Re: EN 010151 - Beacon Fen Energy Park

Boston Borough Council's - Deadline Six Submission – 12th January 2026.

The letter sets out Boston Borough Council (BBC) response to the Applicants Deadline 5 submissions for the above Project.

DO NOT SCALE FROM THIS DRAWING

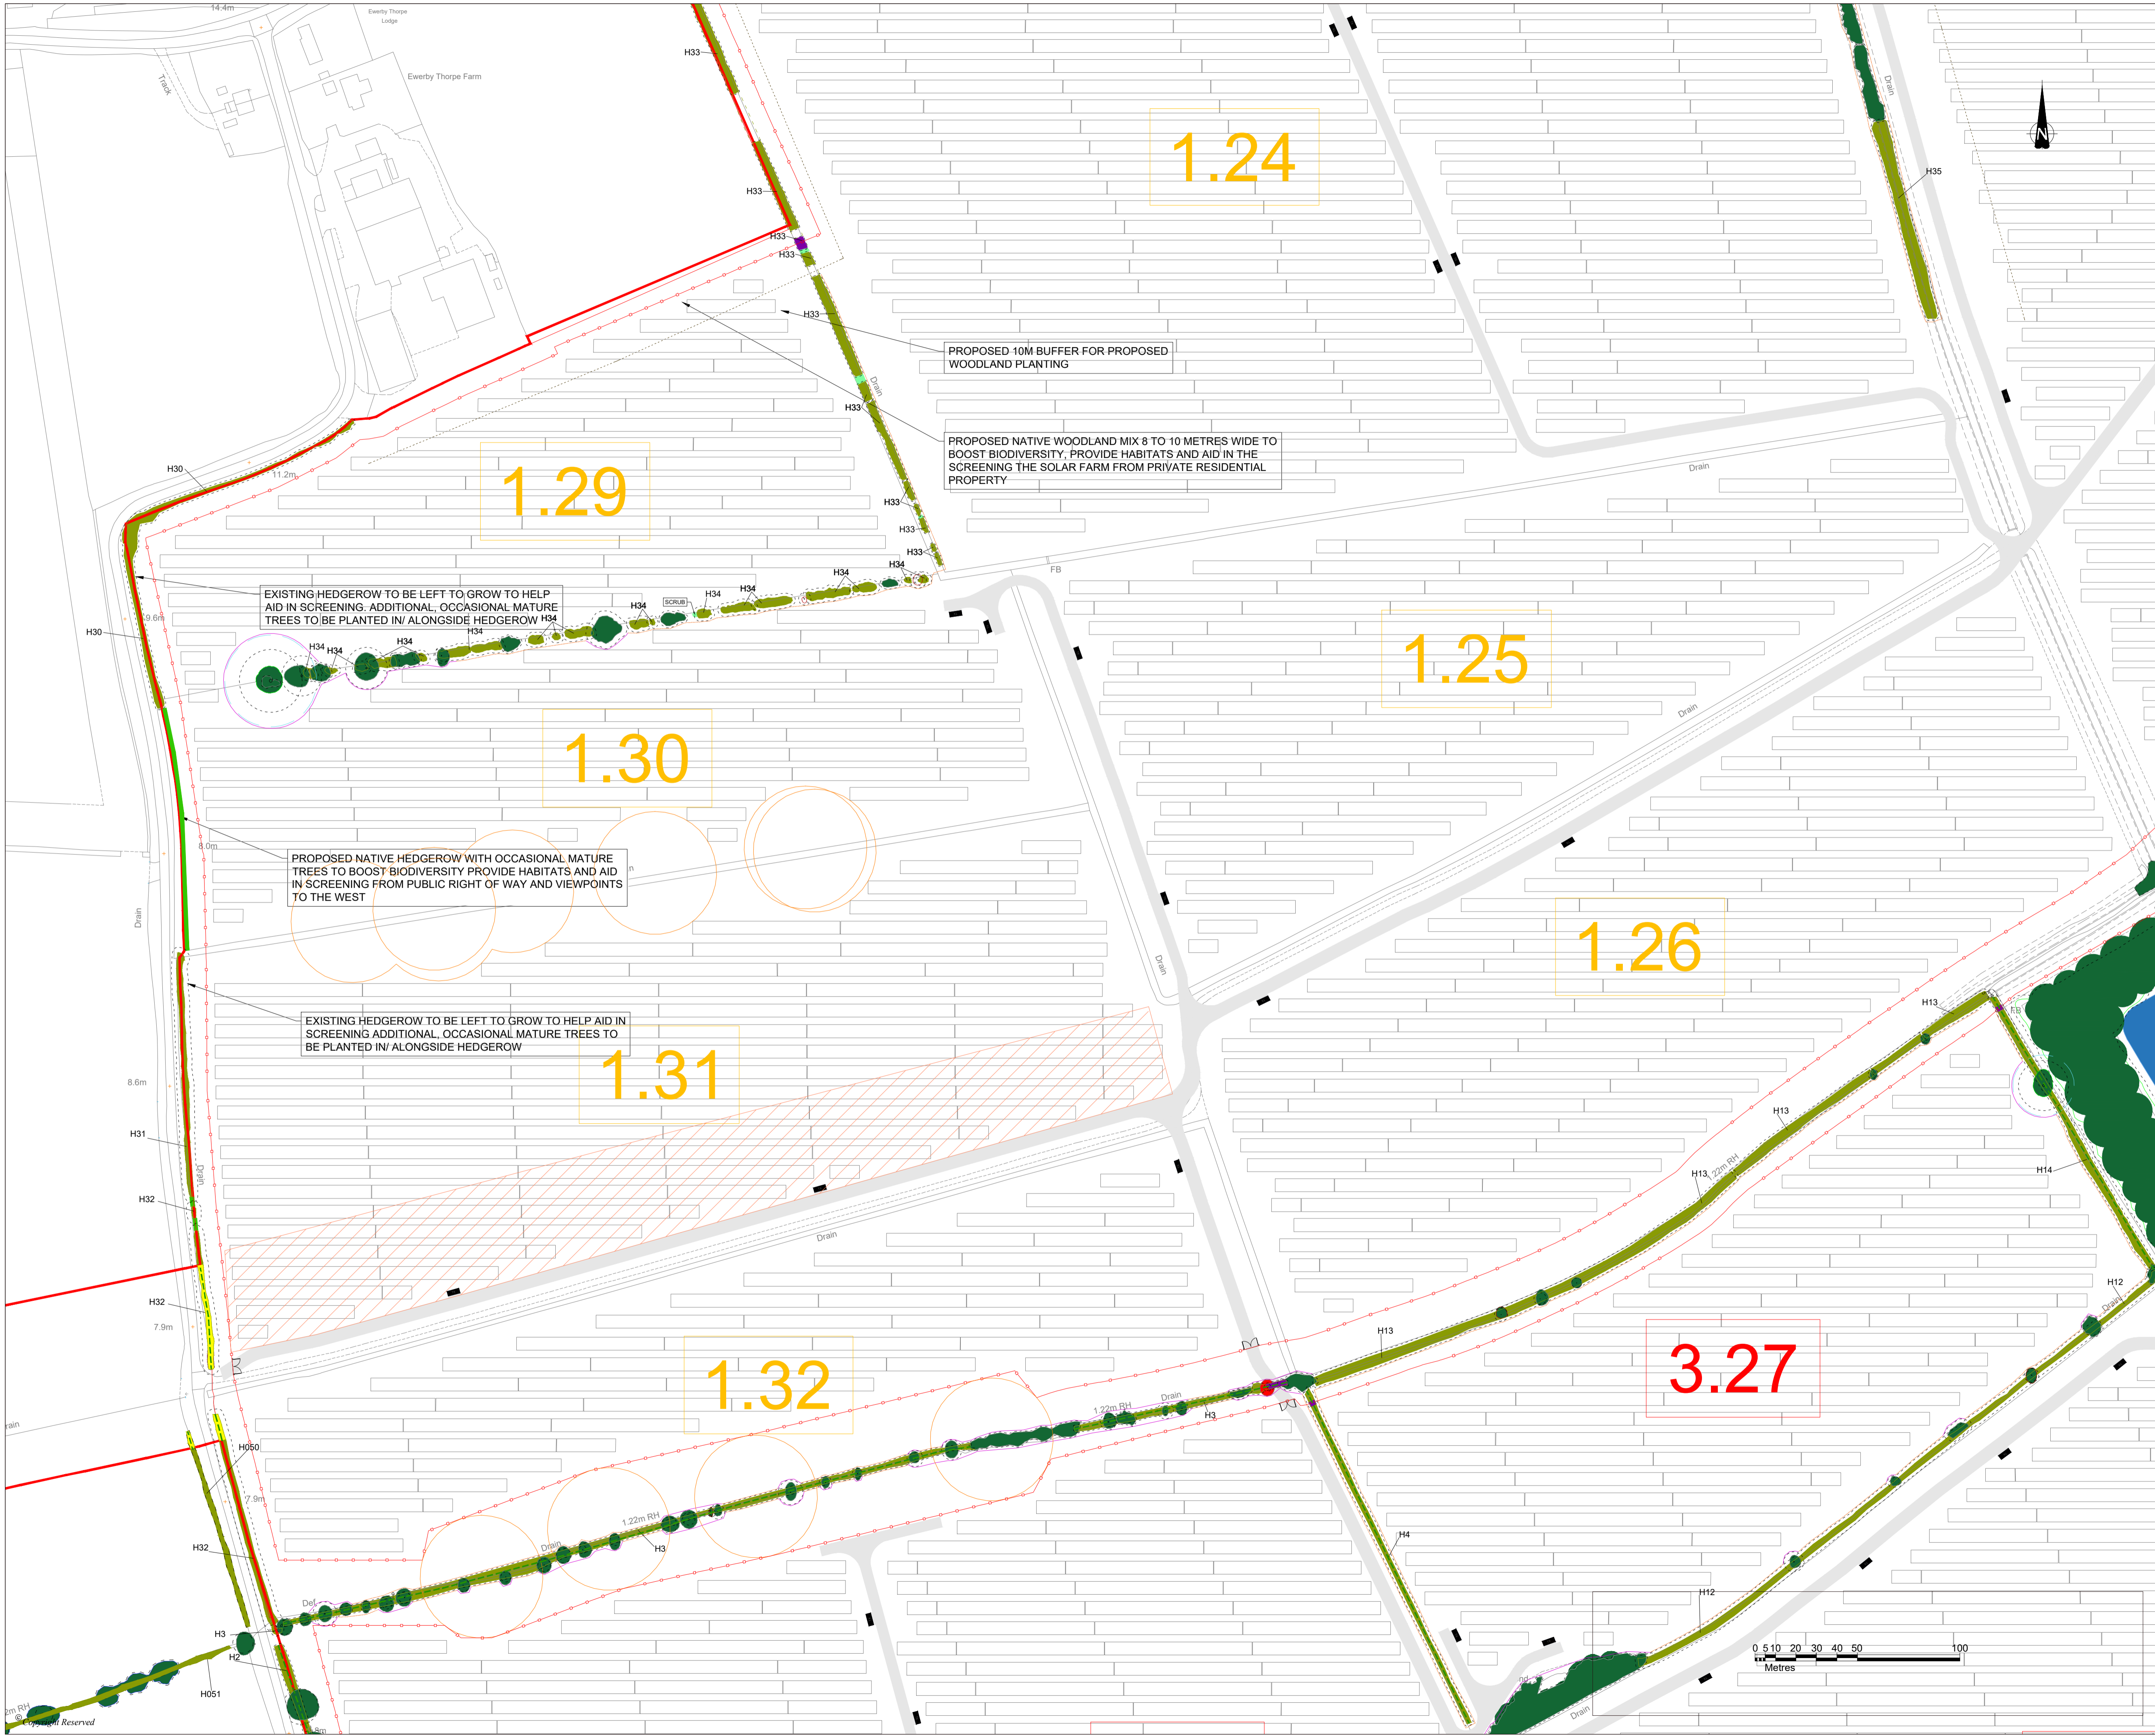
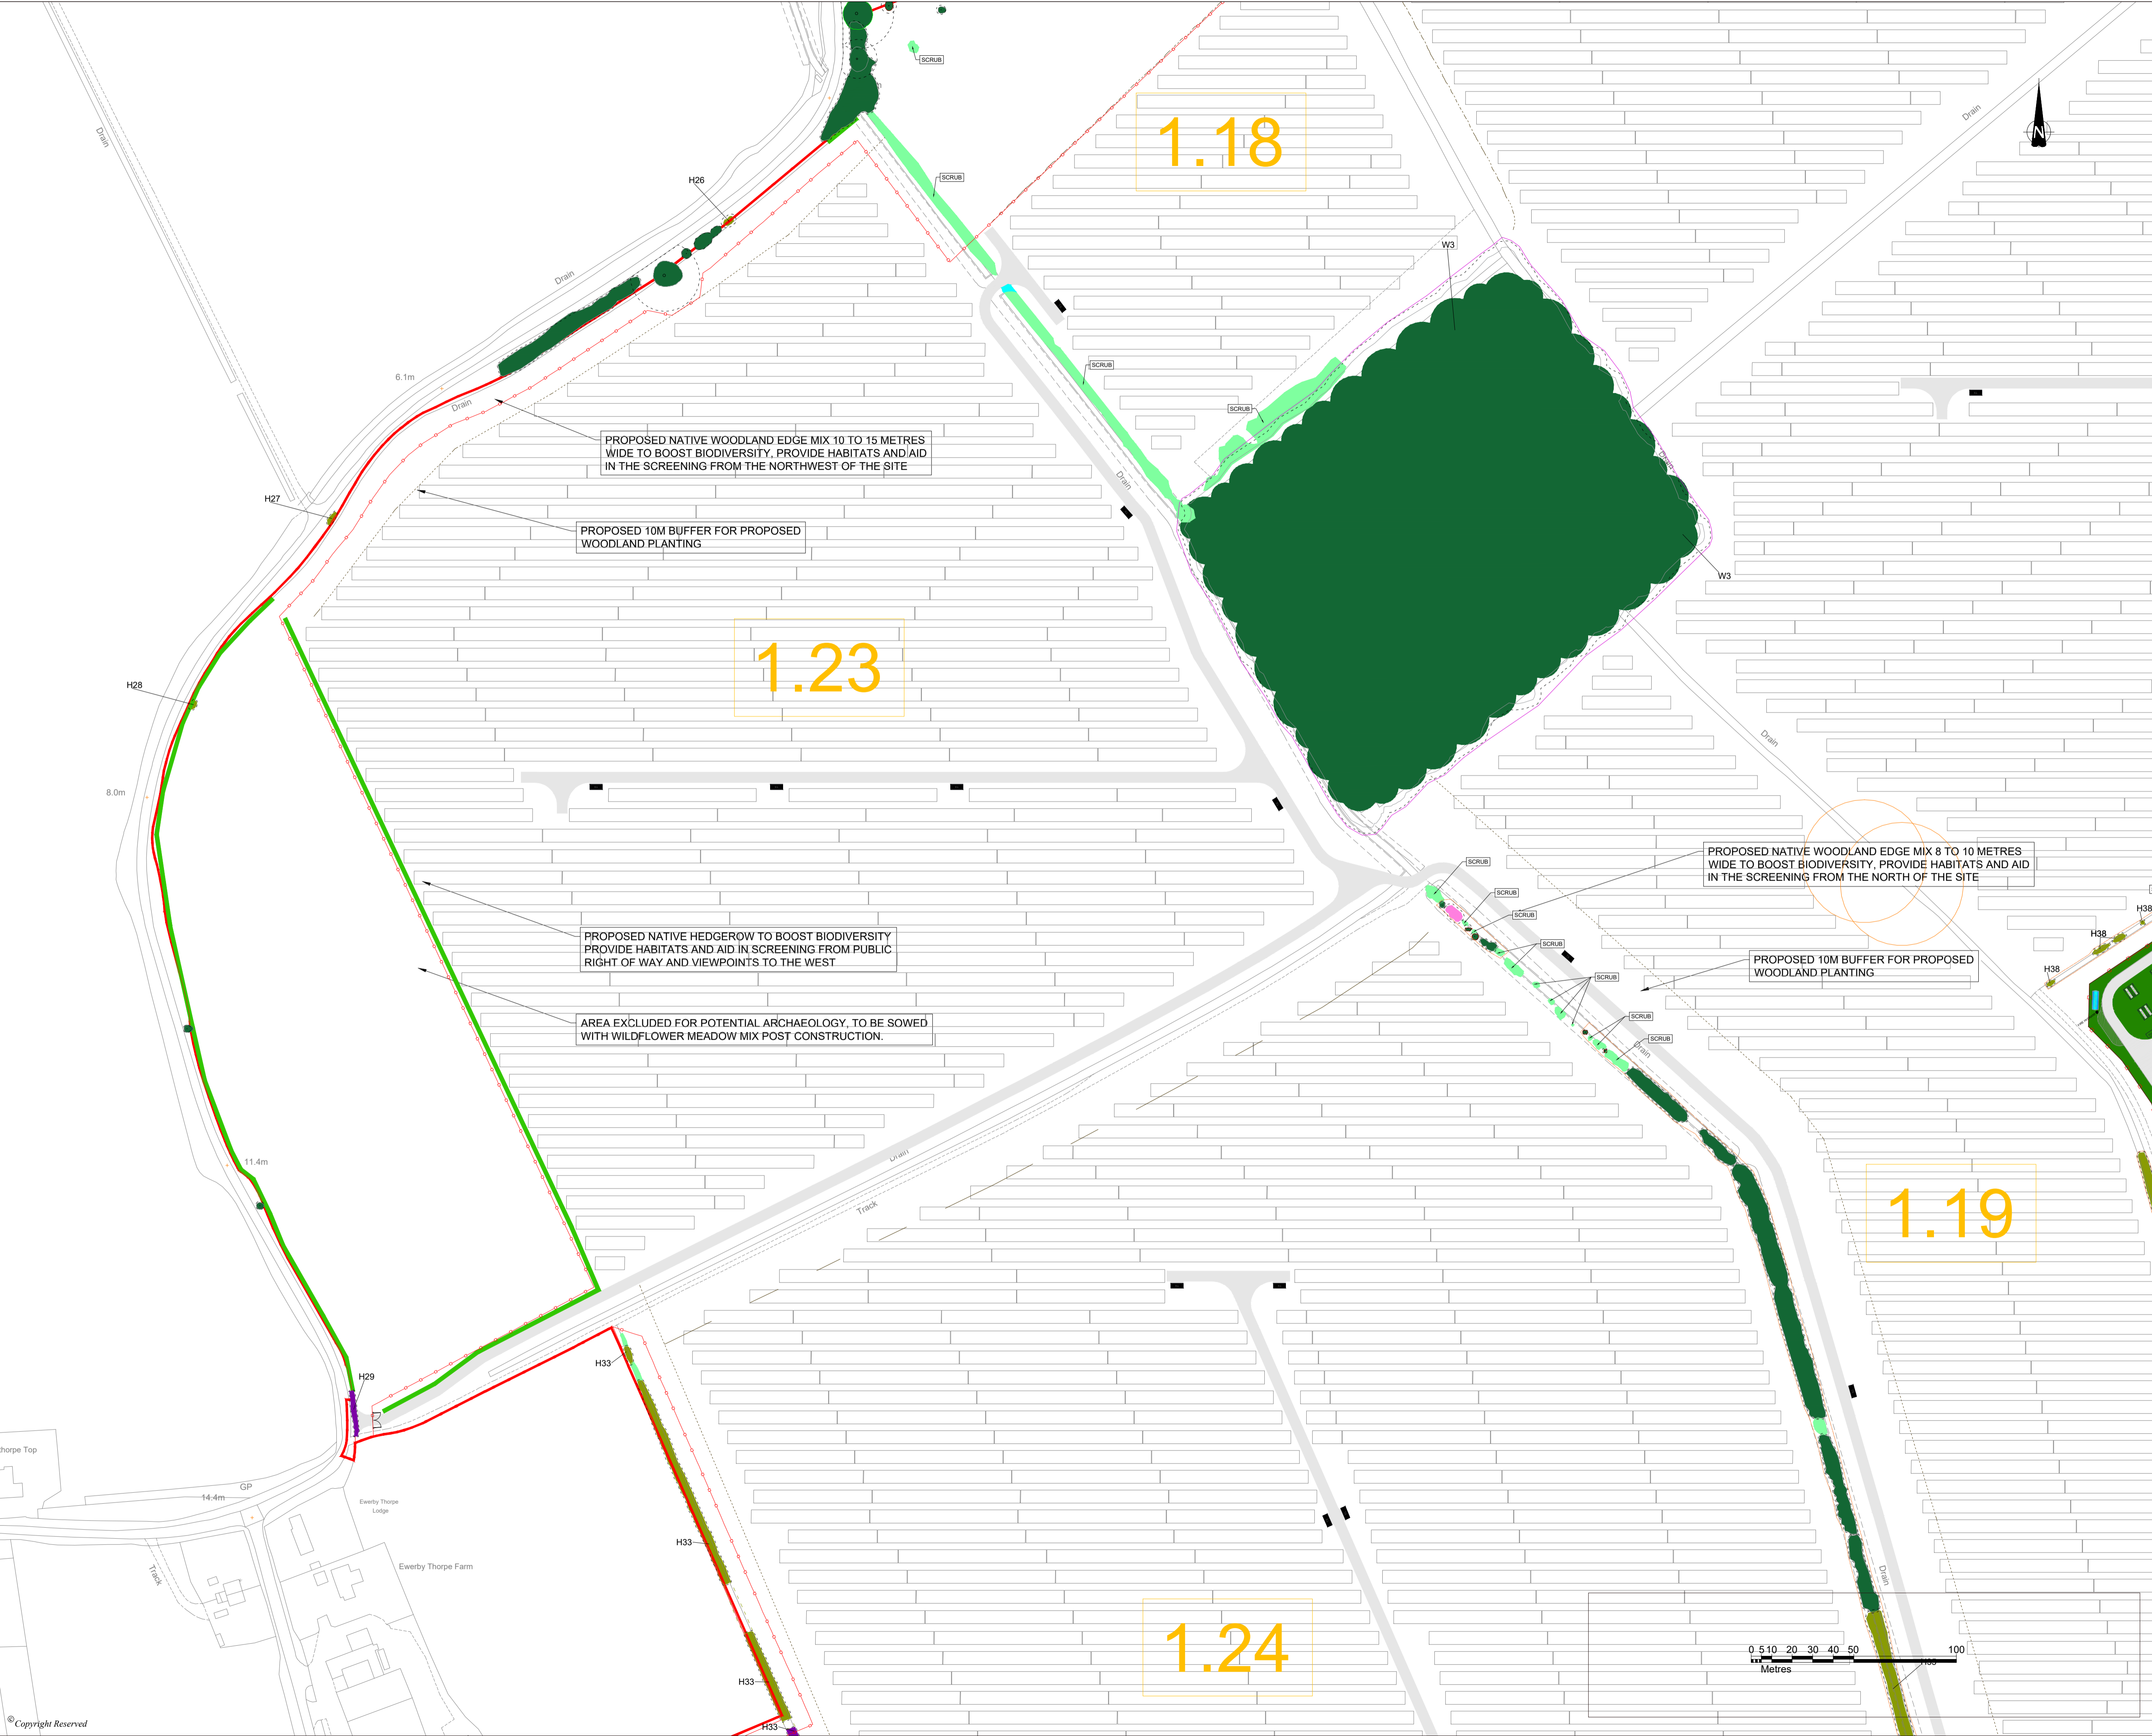
BBC notes that the Change Request accepted by the ExA introduces new infrastructure (Overhead line and Tower) and a revised OLEMP (CR-016) with a landscape strategy plans (CR-021) as well as revised Vegetation Removal Plans (CR-024).

BBC's consultation response to the Applicant in respect of the Change Request requested confirmation of the submission of and how a Vegetation Reinstatement Method Statement, in the event that Work No. 5C and 5D are temporarily be lain to hardstanding, be secured in the dDCO. BBC understands a commitment is to included within the OLEMP and secured by Requirement within the dDCO.
